APPROVED
Limited building only review
Permit holder responsible for full compliance with the code

Revised floor truss to I Joist after plan approval. Approved revision 11/05/2021

The Redwood

Drawing file: SFD2103-0107 / Lot 14 Forest Ridge FL.pdf

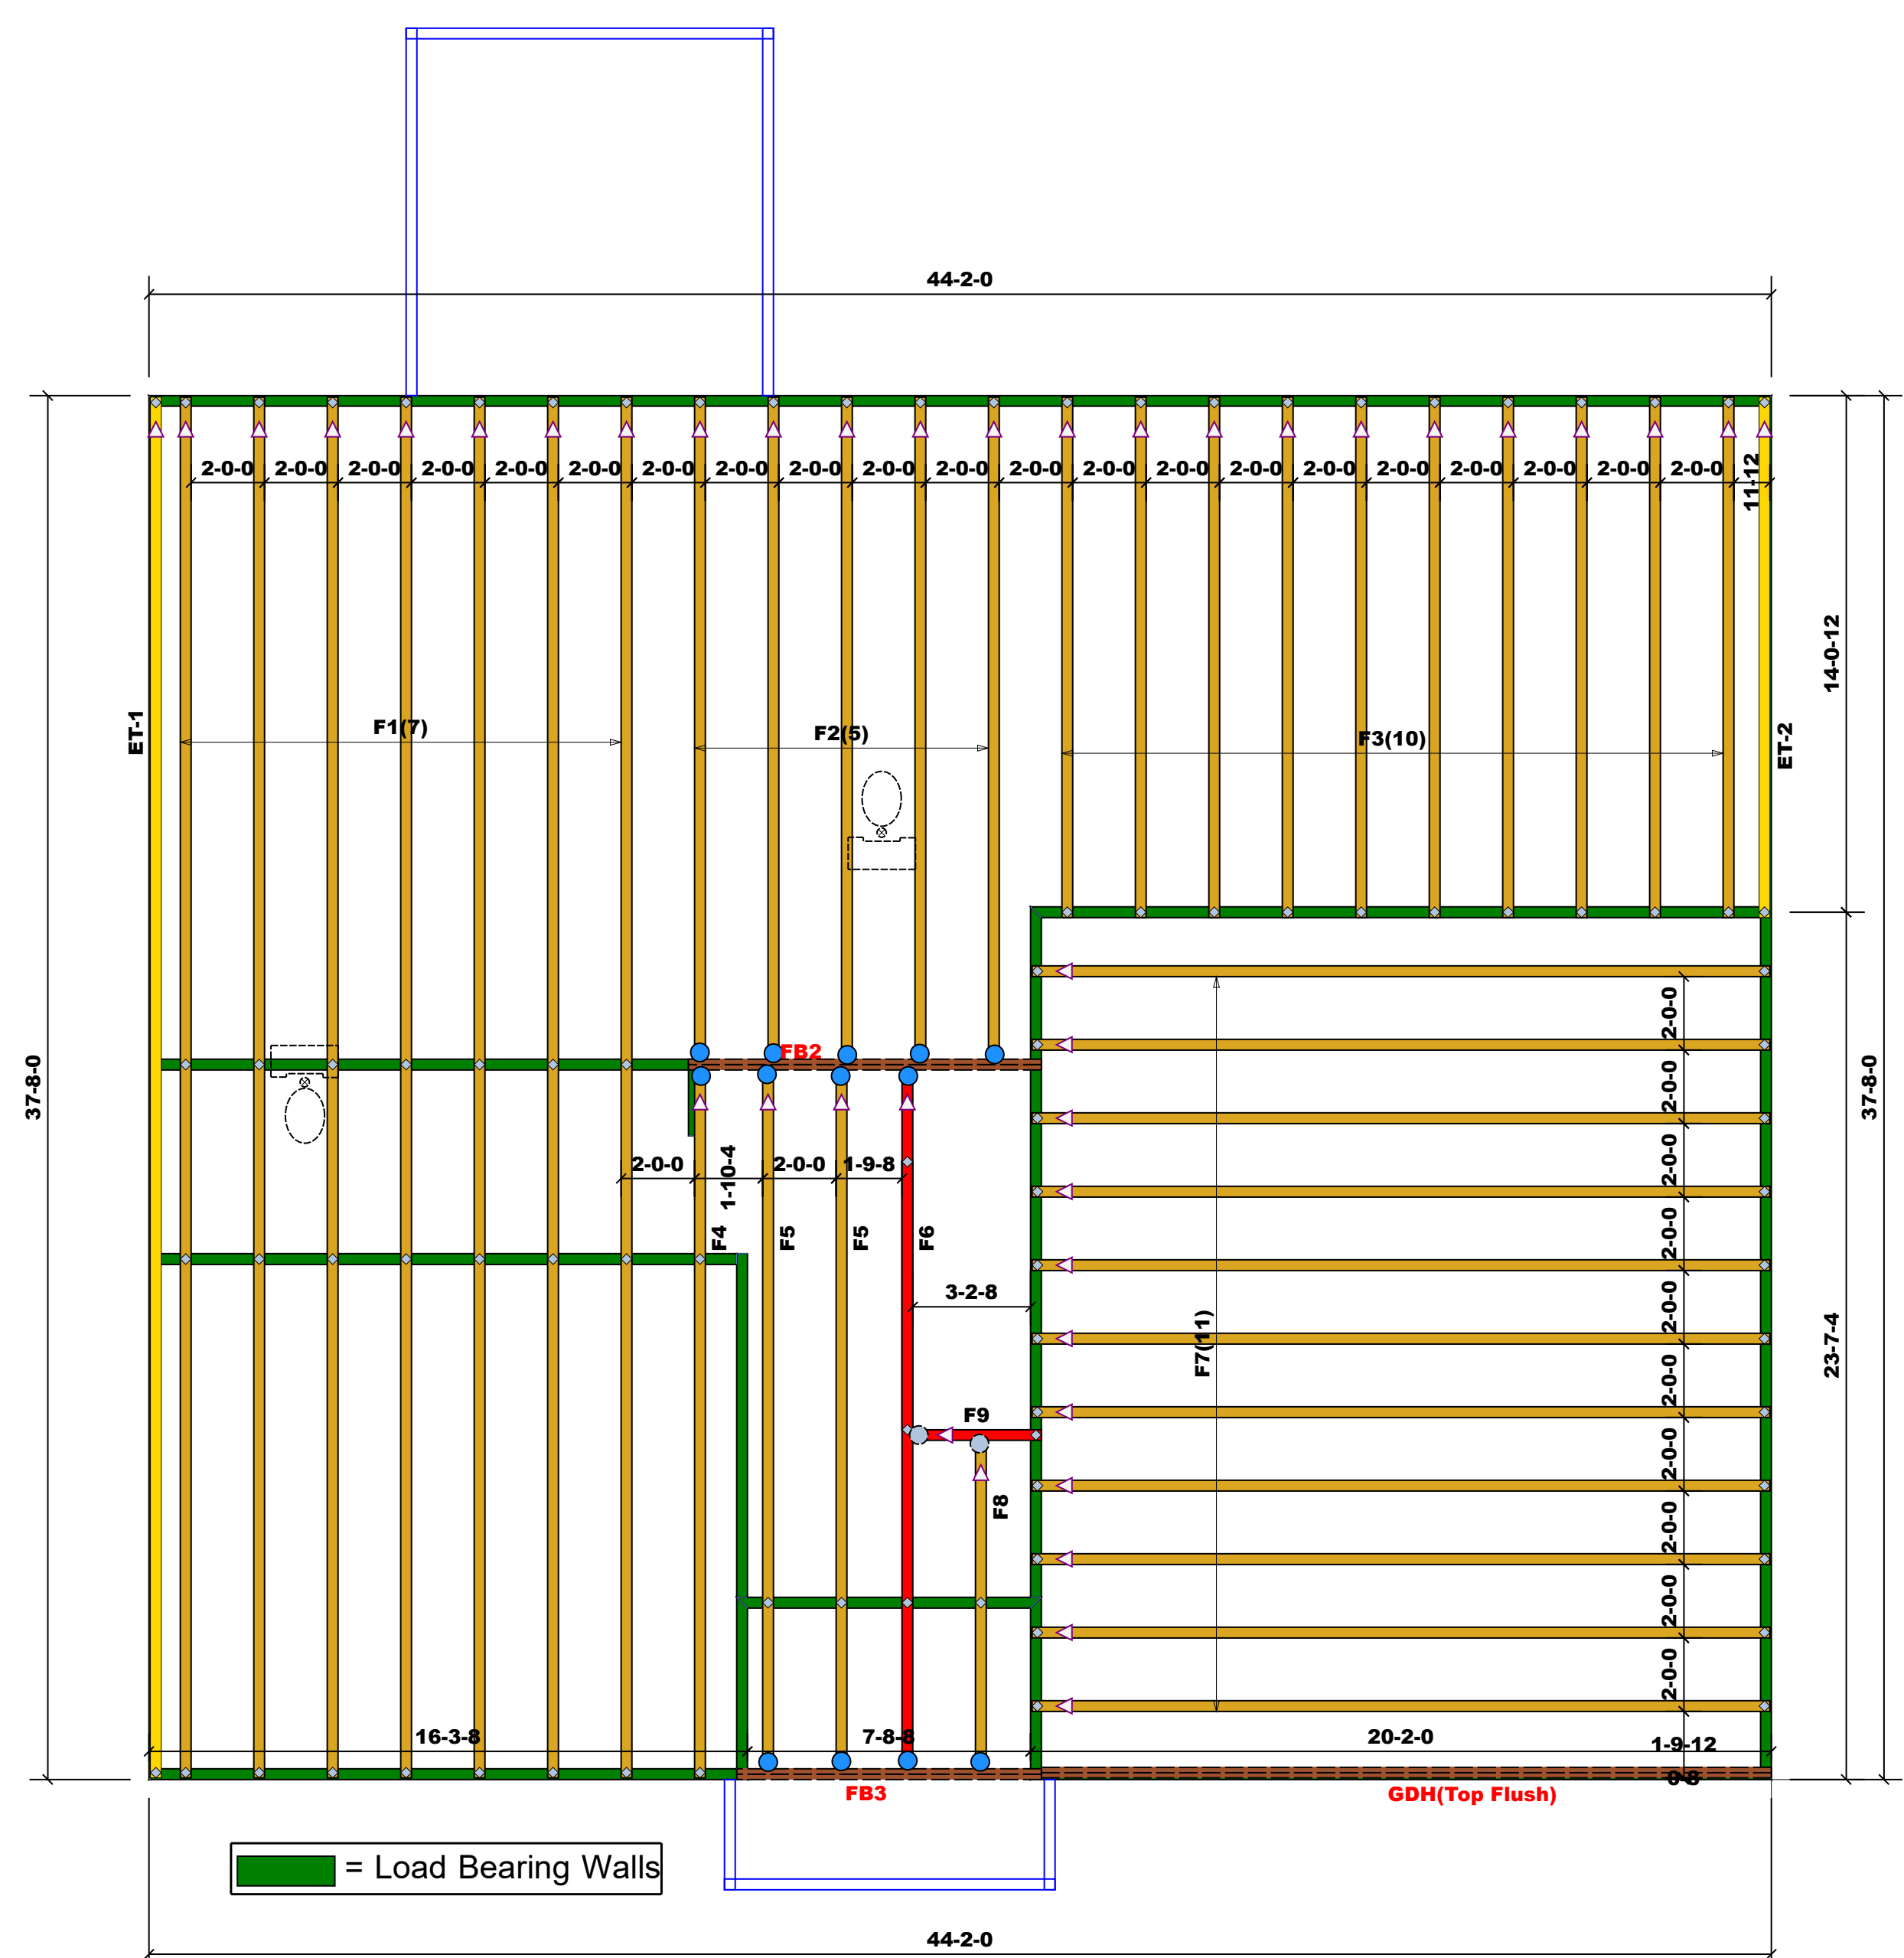
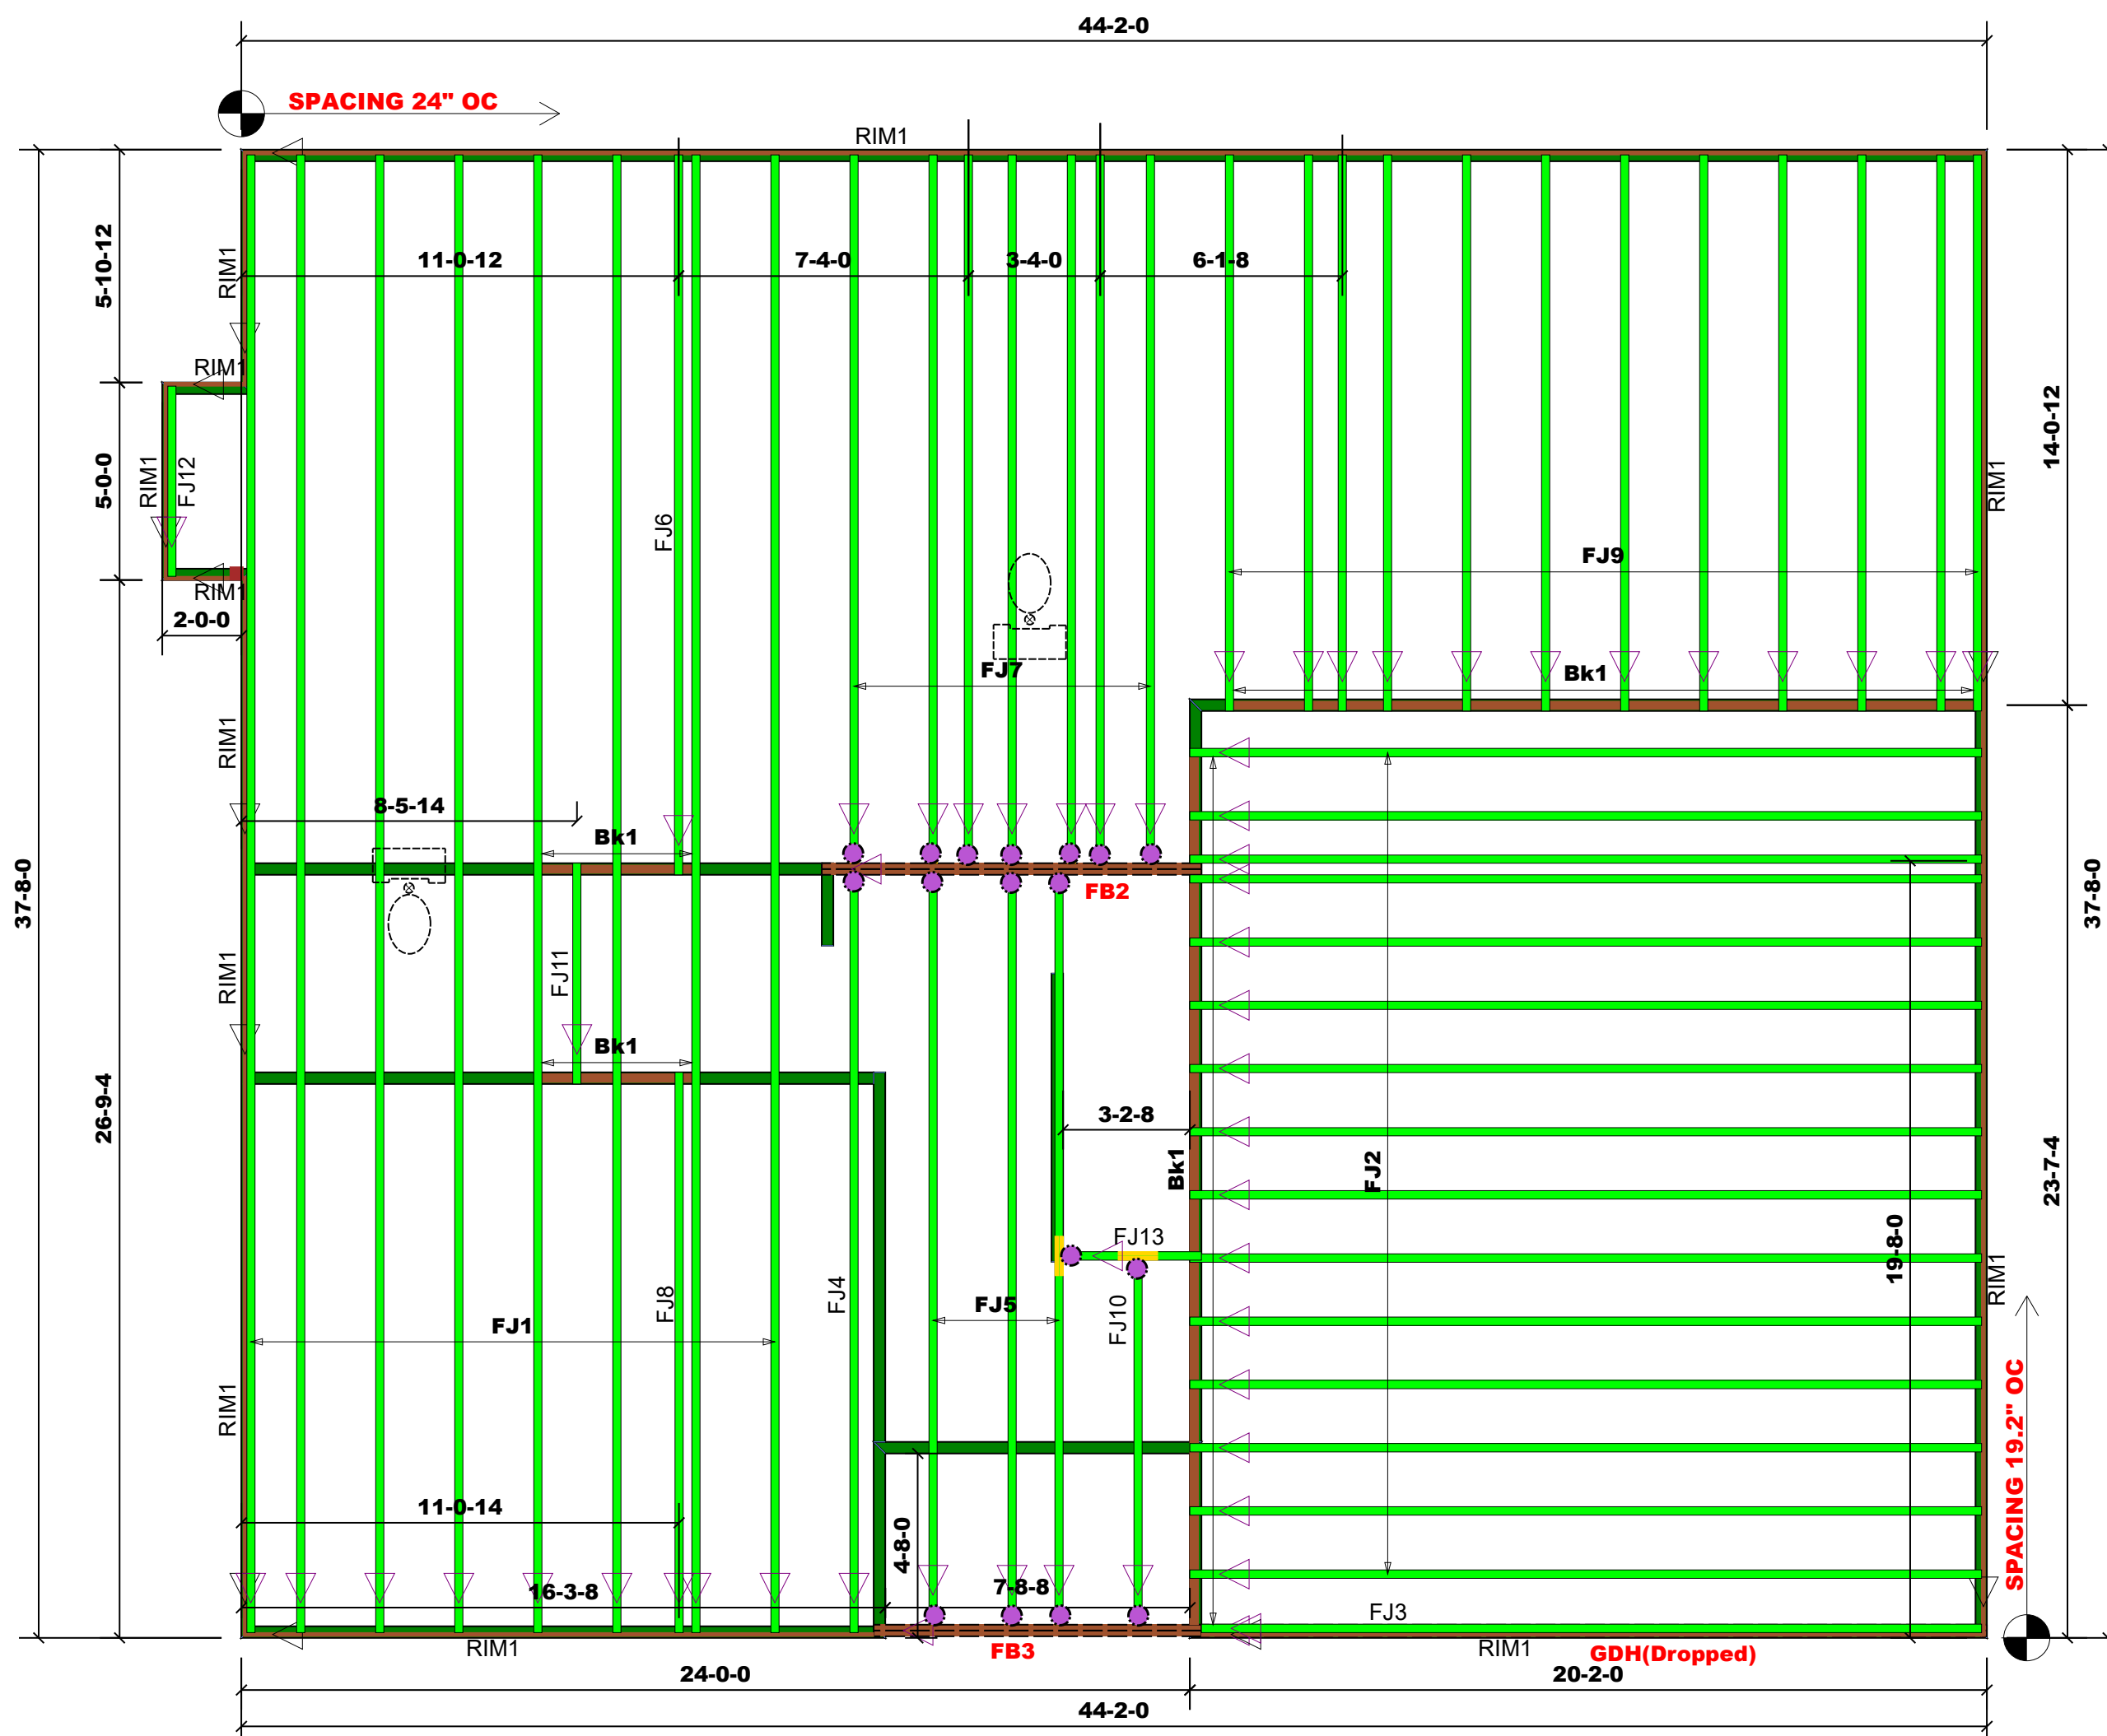
Revised to I joist after permit issuance/plan approval. Stop it. See revised layout.

Revised floor layout. Approved 11/05/2021
